Our reference: DOC15/485122
Contact: Jacqueline Roberts

The Environment Protection Authority (EPA) received the Department of Planning and Environment's (DPE's) letter dated 2 November 2015 inviting comment on Brickworks Ltd's development application SSD 6820 on exhibition for the construction and operation of a Light Weight Aggregate (LWA) Facility located at 780 Wallgrove Road, Horsley Park.

The EPA has reviewed the development application and supporting Environmental Impact Statement (EIS) prepared by McKenzie Group Consulting Planning (NSW) Pty Ltd dated October 2015. Based on the information provided to date the EPA is unable to issue General Terms of Approval. The EPA's comments supporting this position are outlined below.

Figure 11: Annual and Seasonal Wind Roses for 2014 – CALMET Predictions

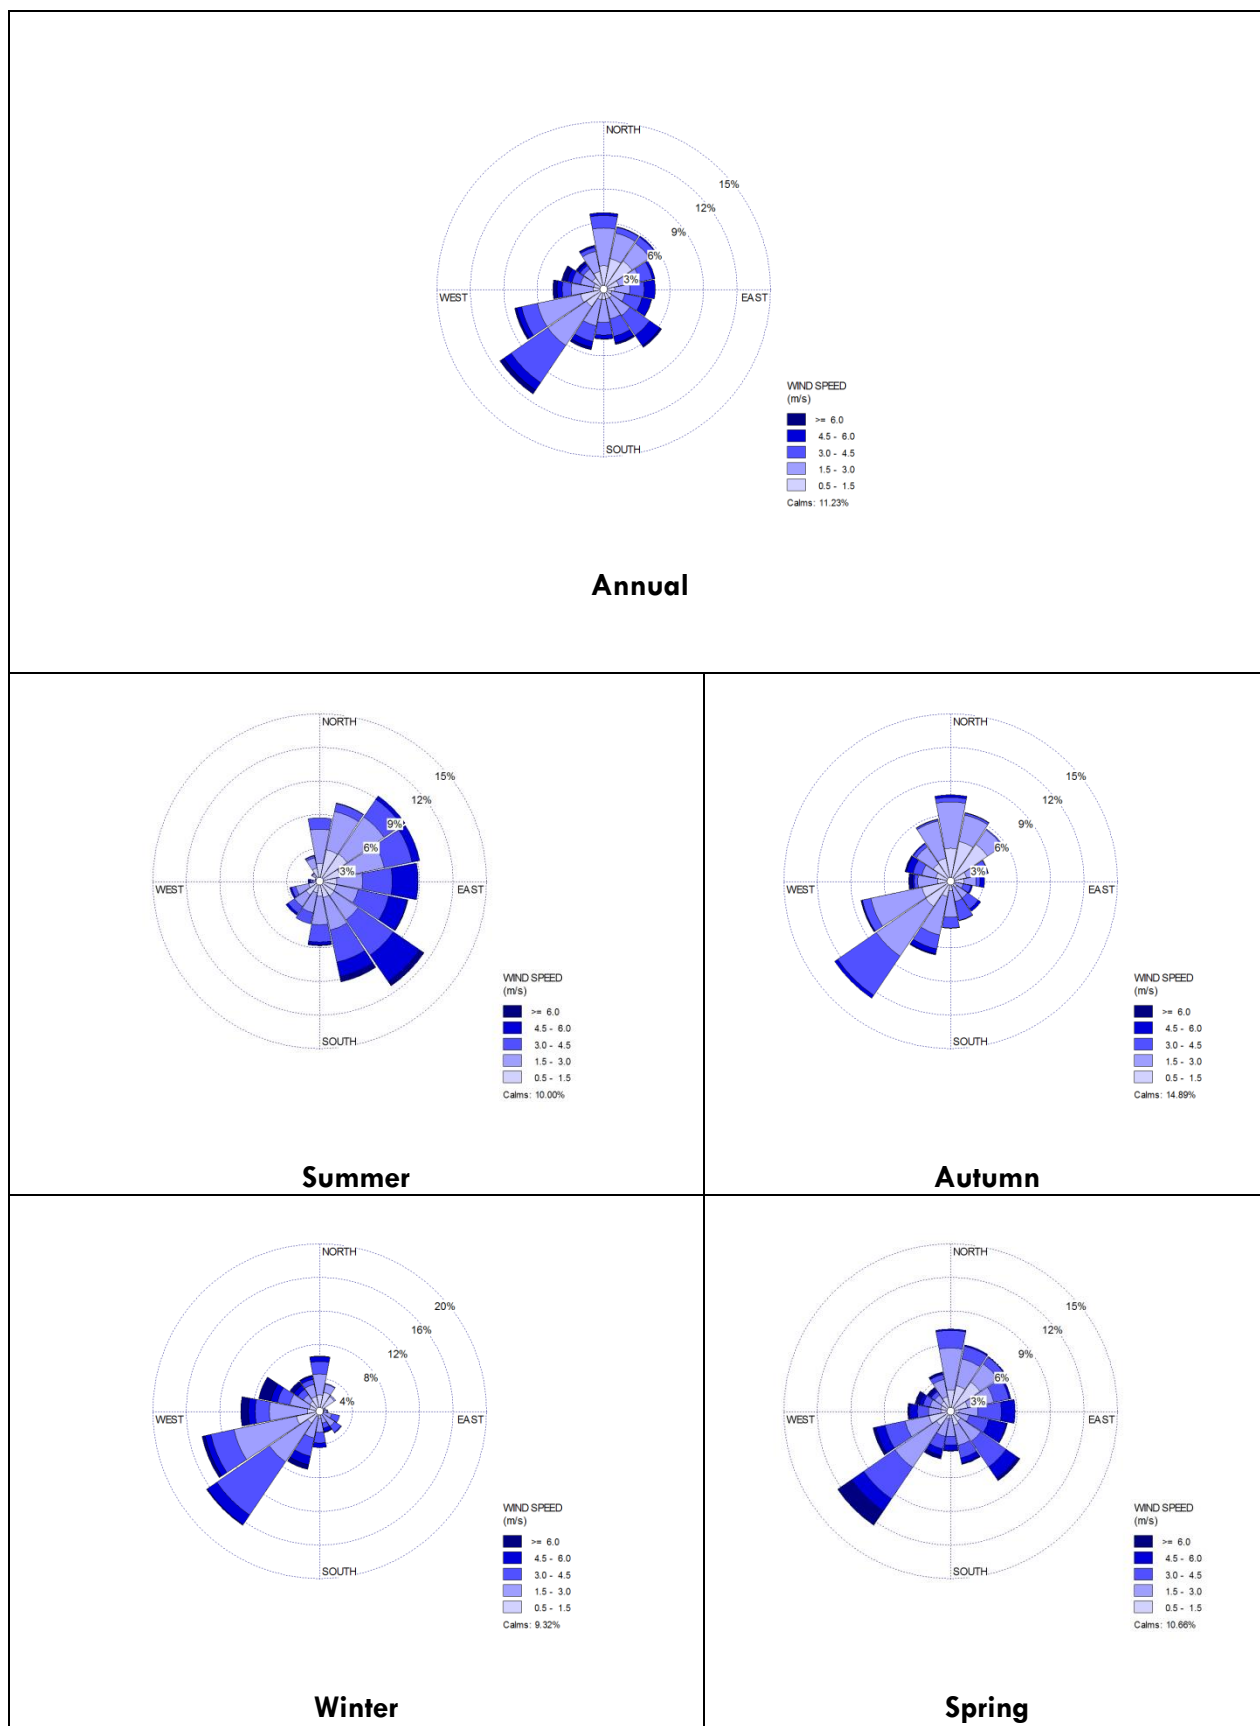
CALMET was operated in no-obs mode and includes model settings in accordance with OEH, 2011¹. Such a method is endorsed. The assessment provides wind rose diagrams for a point located within the CALMET modelling domain, presumably at the proposed sites location, however this is not made clear in the report. It is noted that the presented information on the CALMET meteorological data contains differences with the information presented on the BoM Horsley Park data, specifically in relation to the percentage of calm conditions. Calm conditions are adverse for air dispersion. A summary of the compared quantity of calm conditions is tabulated below.

Season	CALMET (Figure 11 of AQIA)	BoM (Figure C-5 of AQIA)
Annual	11.23 %	16.67 %
Summer	10.00 %	13.24 %
Autumn	14.89 %	22.84 %
Winter	9.32 %	13.67 %
Spring	10.66 %	17.66 %

The EPA recommends the AQIA include further validation of the meteorological data utilised for dispersion modelling purposes with a focus on the discrepancies between the quantity in calm conditions between the observation data and the CALMET generated data.

Figure C-5: Annual and Seasonal Wind Roses for 2014 – BOM Horsley Park Equestrian Centre AWS

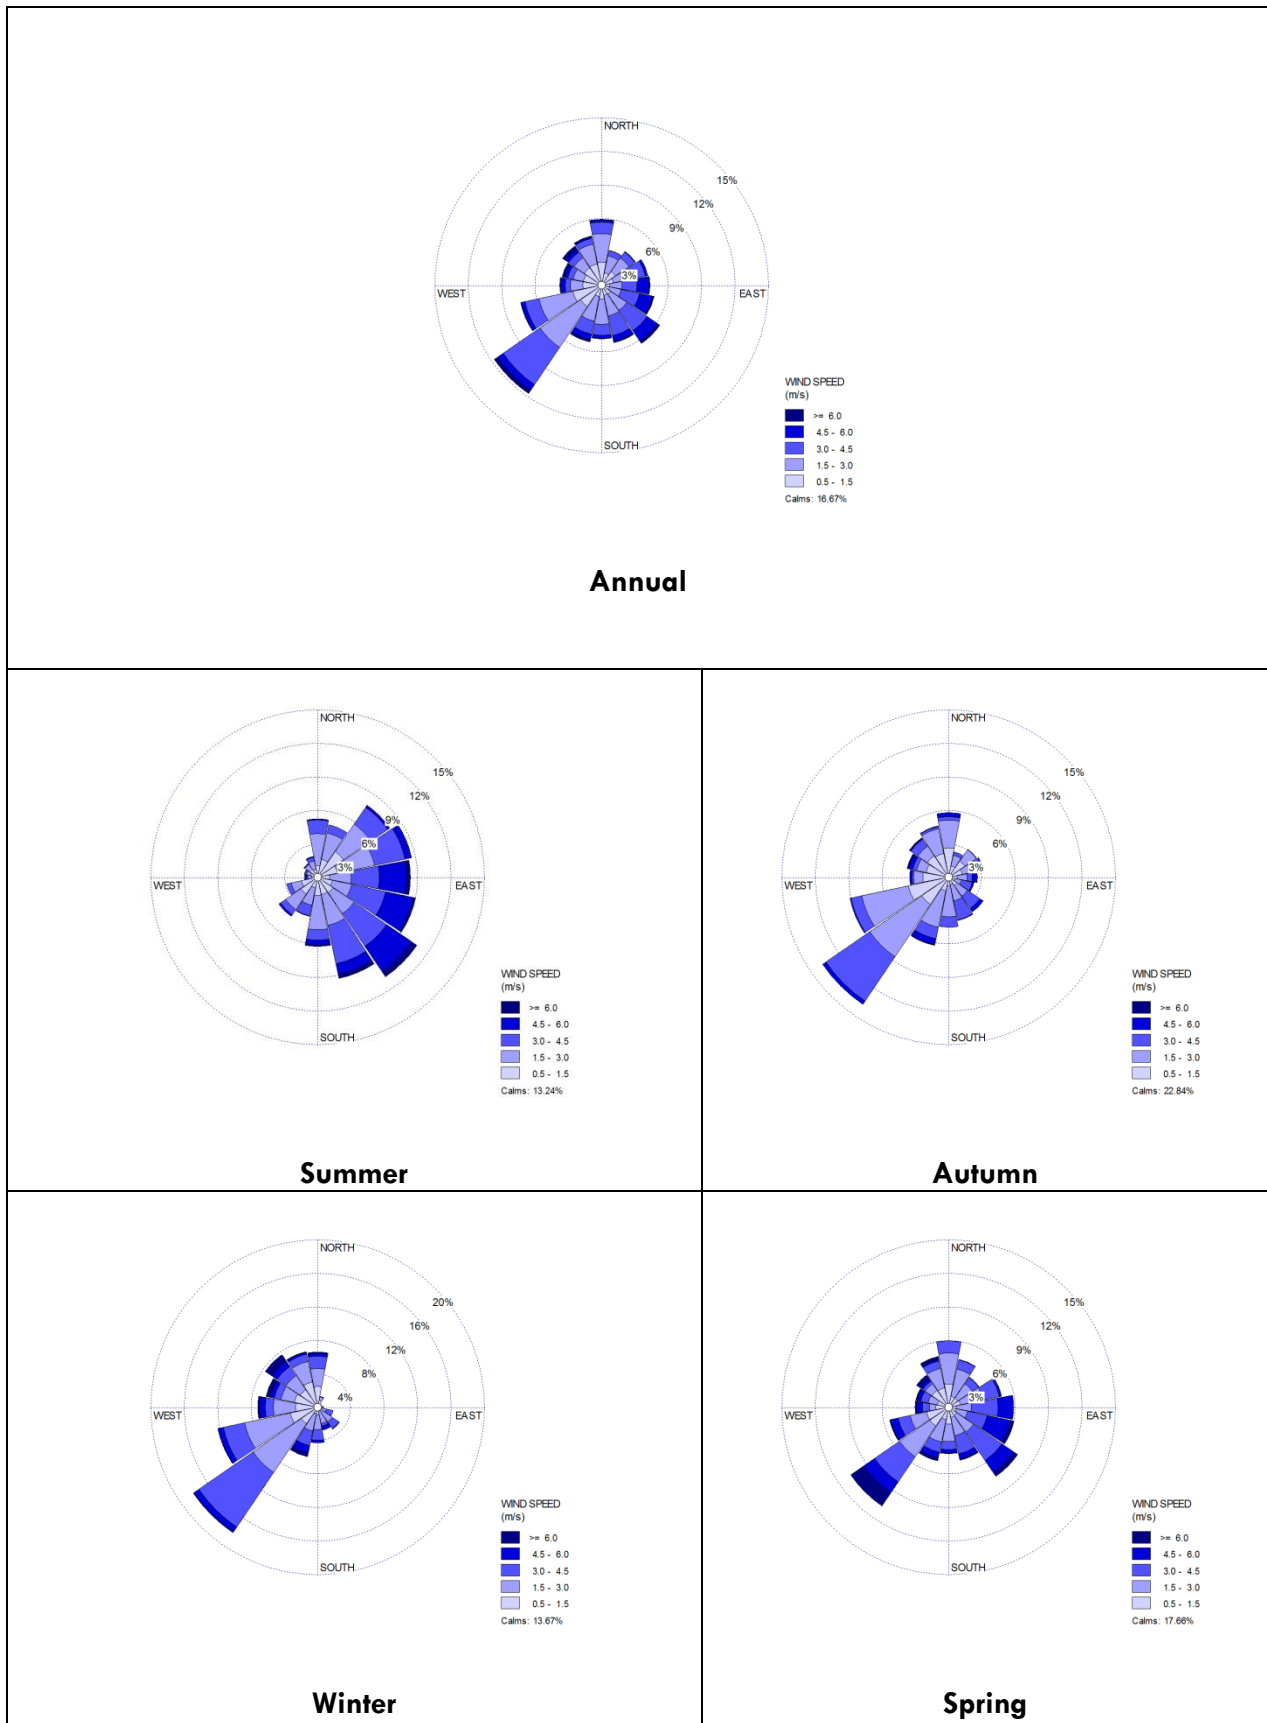
The assessment outlines that based on analysis of the meteorological data from 2010-2014 at the Bureau of Meteorology (BoM) Horsley Park Automatic Weather Station (AWS), 2014 was considered to be a representative year. However the analysis (provided as Appendix C of the AQIA) is limited to the compilation of wind roses without specific analysis or discussion. Windroses are considered one tool for determining the representative nature of a meteorological data set.

The EPA recommends that the AQIA includes further analysis to demonstrate 2014 is considered a representative year for assessment purposes.
